# Rezoning Transportation Analysis

Petition Number: #2022-084

Date	Description
11-28-22	First Review (TM)
12-15-22	Second Review (DR)
02-22-23	Third Review (TM)
03-28-23	Fourth Review (TM)

**SCHEMATIC**  
**SITE PLAN**

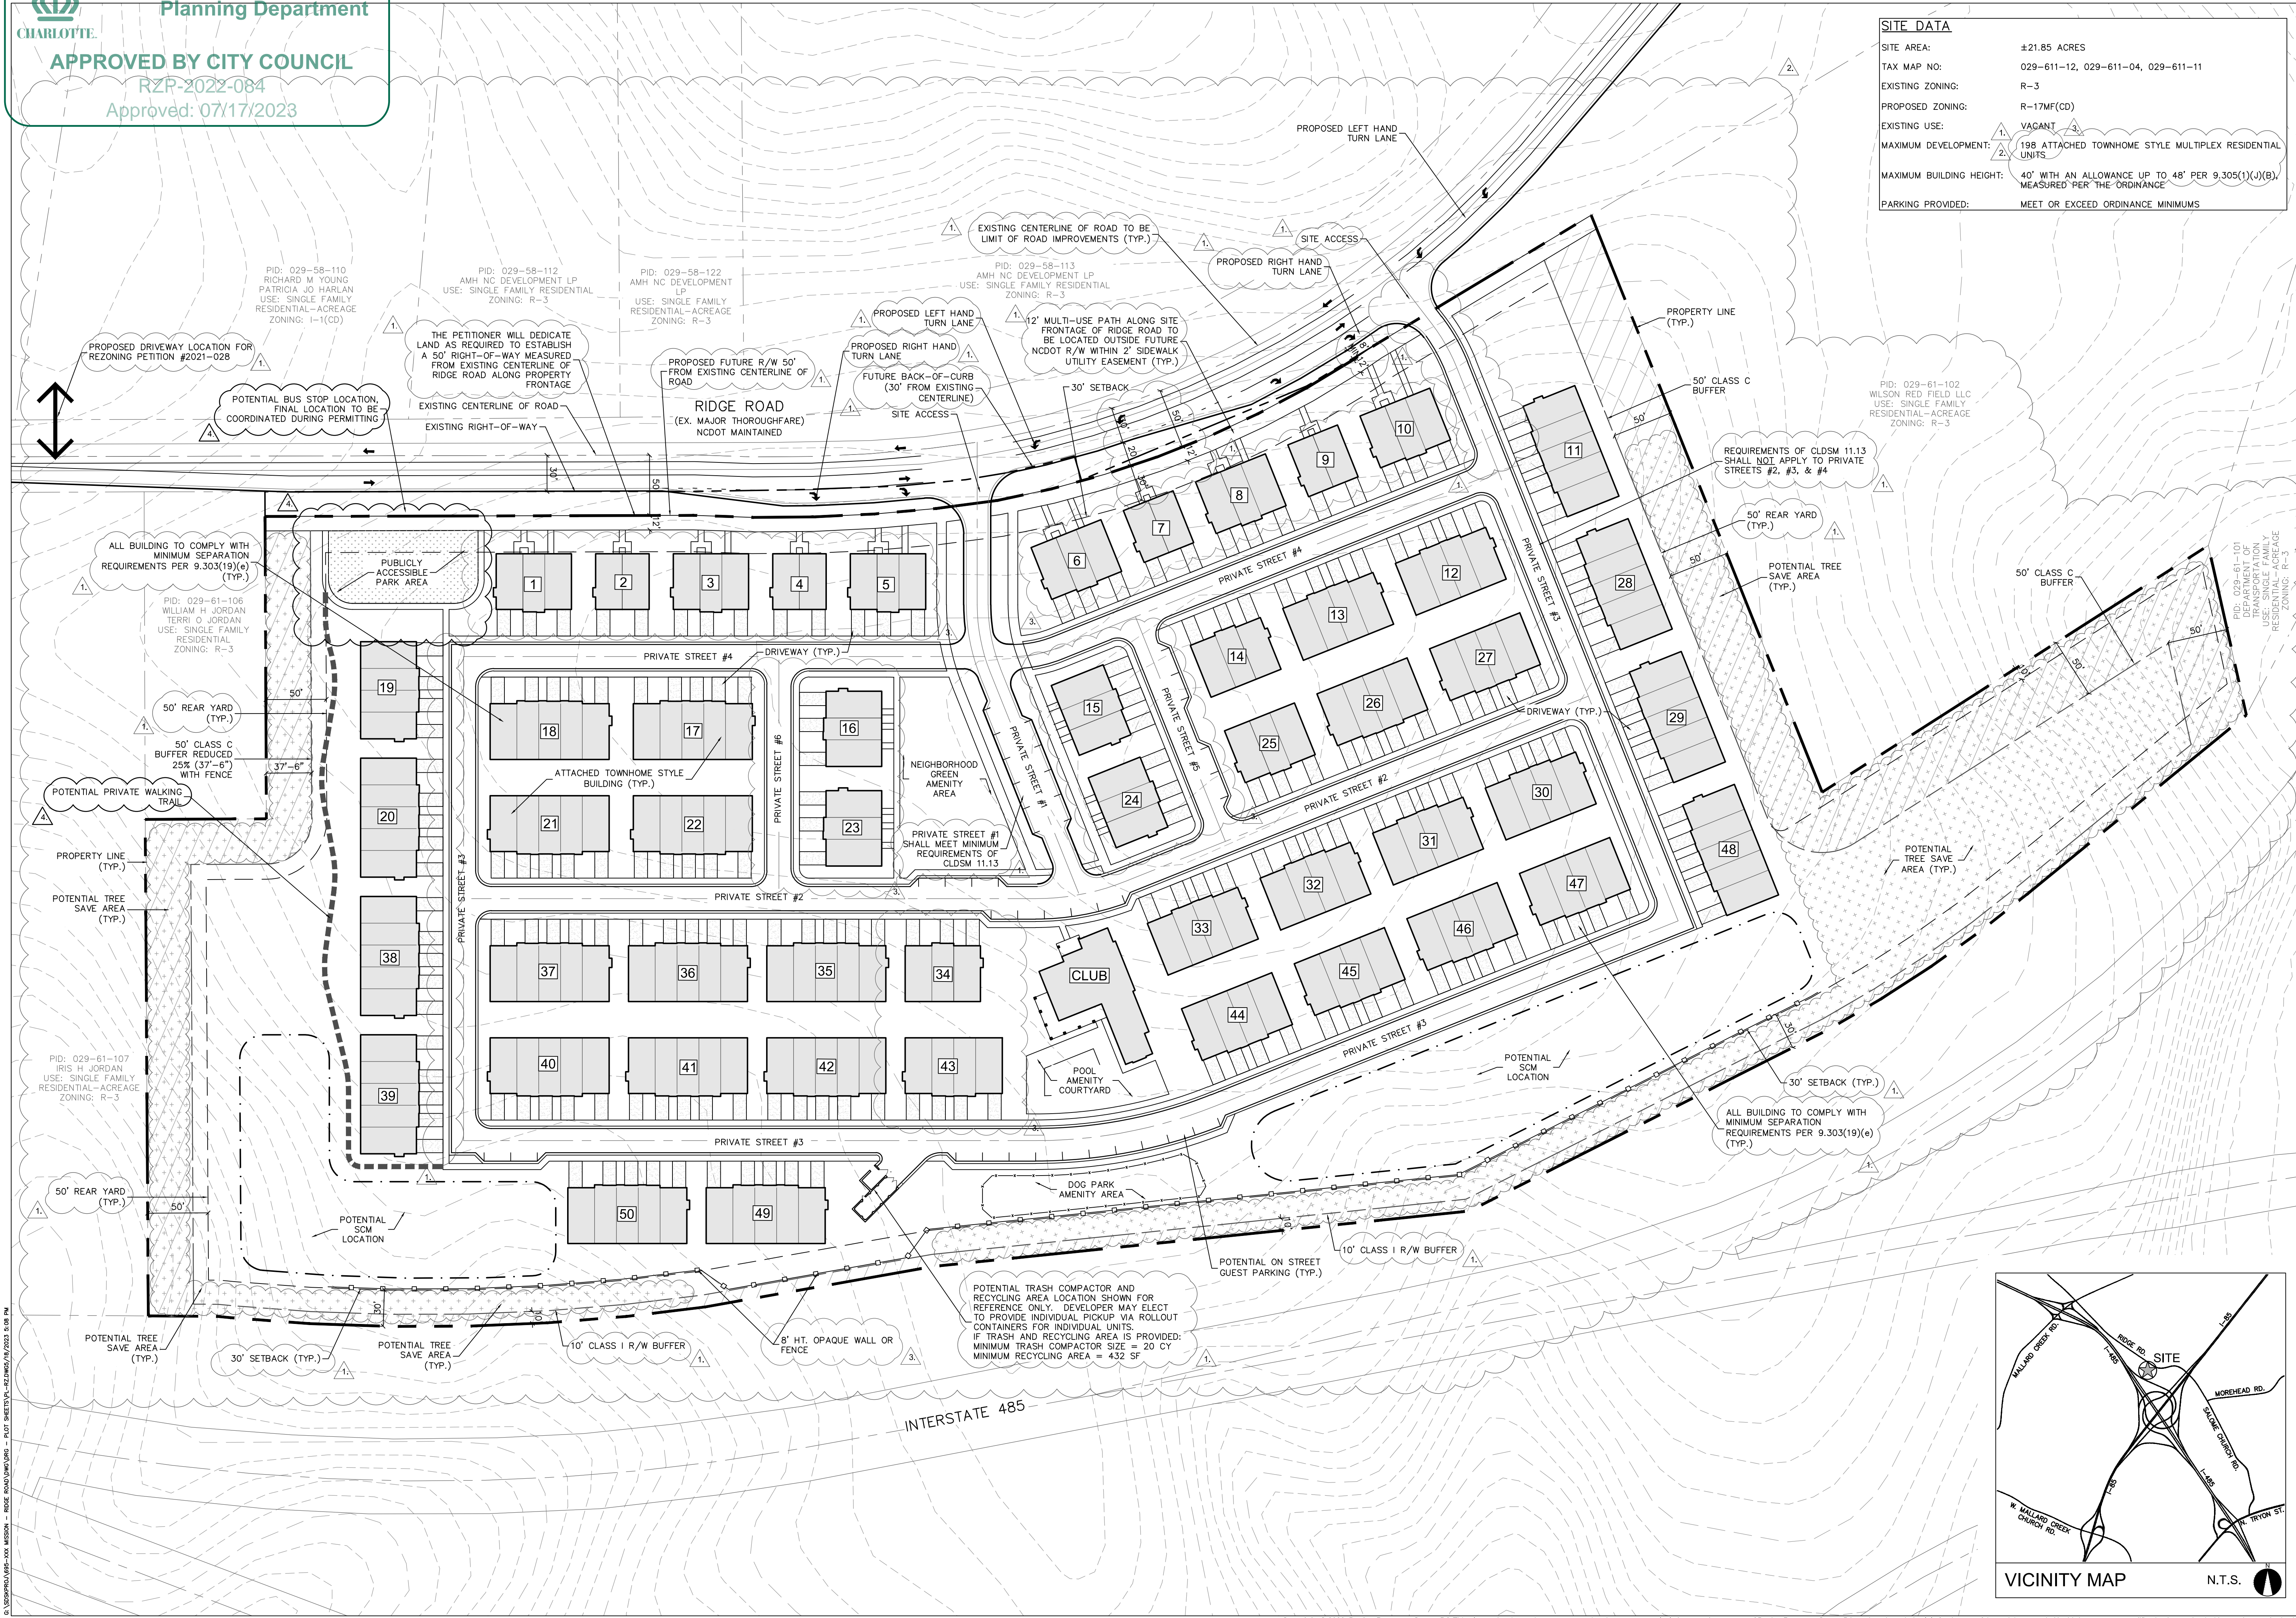
- ~~**Curbline:** The proposed zoning district has a setback measured from back of the existing or proposed future curbline.~~
  - ~~**Ridge Road:** The future location of curb and gutter is measured at 30 feet from the centerline of the roadway to the BOC.~~

Label and dimension the curb and gutter from the centerline for each road on the site plan.

3. ~~Revise site plan and conditional note(s) to commit to dedicate 50 feet of right of way from the road centerline. The site plan shall label and dimension the right of way from the road centerline.~~

5. ~~Site plan and conditional note(s) revisions are needed to commit to constructing a full three lane section on Ridge Road along the site frontage. 3 lane section to include a two-way left turn lane along the site frontage and two through lanes. Dimension the transition length and width of the two-way left turn lane along Ridge Road per NCDOT comments.~~

6. ~~Site plan and conditional note(s) revisions are needed to commit to constructing a right turn at both driveways per NCDOT comments.~~
7. ~~Site plan and conditional note(s) revisions are needed to commit to aligning site entrances with the Kings Grant rezoning (2021-028). Site plan shall show linework from Kings Grant development along Ridge Road. **Comment Rescinded 12-22-22**~~

11. ~~Revise site plan to construct a 12 foot multi-use path on Ridge Road. The site plan shall label and dimension both items from the back of curb and gutter and road centerline. The entire facility must be outside of the right of way and within a public access easement. Add conditional note committing to construction and maintenance of the 12 foot multi-use path on Ridge Road.~~

**PRIVATE STREET MINIMUM SECTIONS #1**

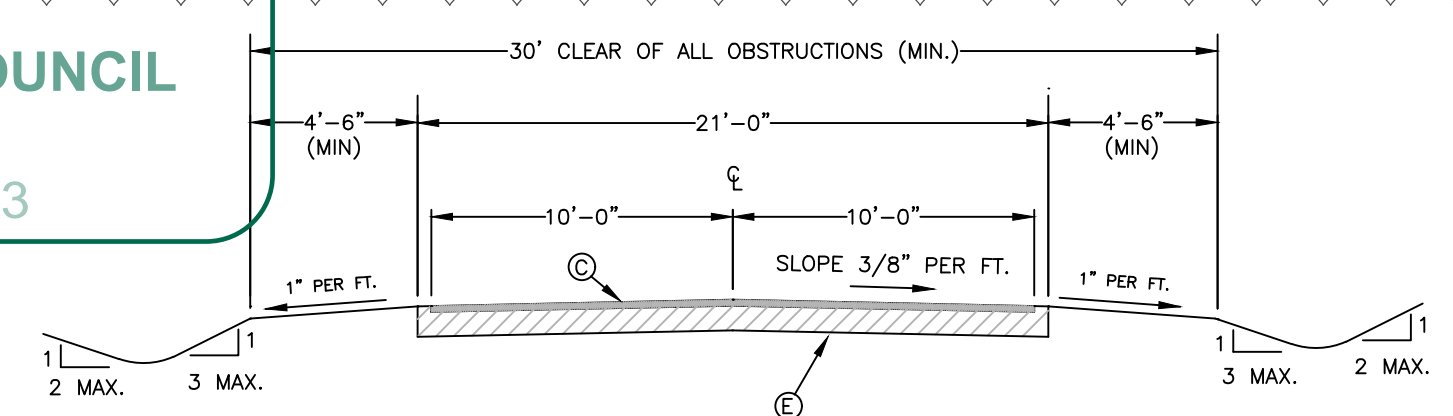
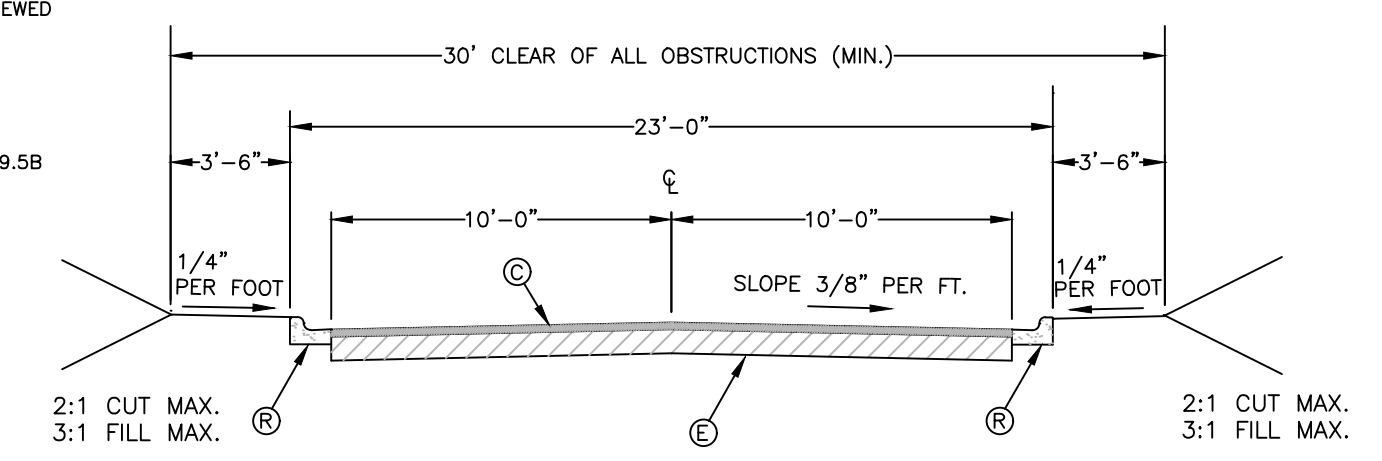
4. ~~Site plan and conditional note(s) revisions are needed to commit to constructing internal private roads to meet or exceed CLDSM standard 11.13. Site plan shall callout CLDSM 11.13 and add roadway cross section detail.~~
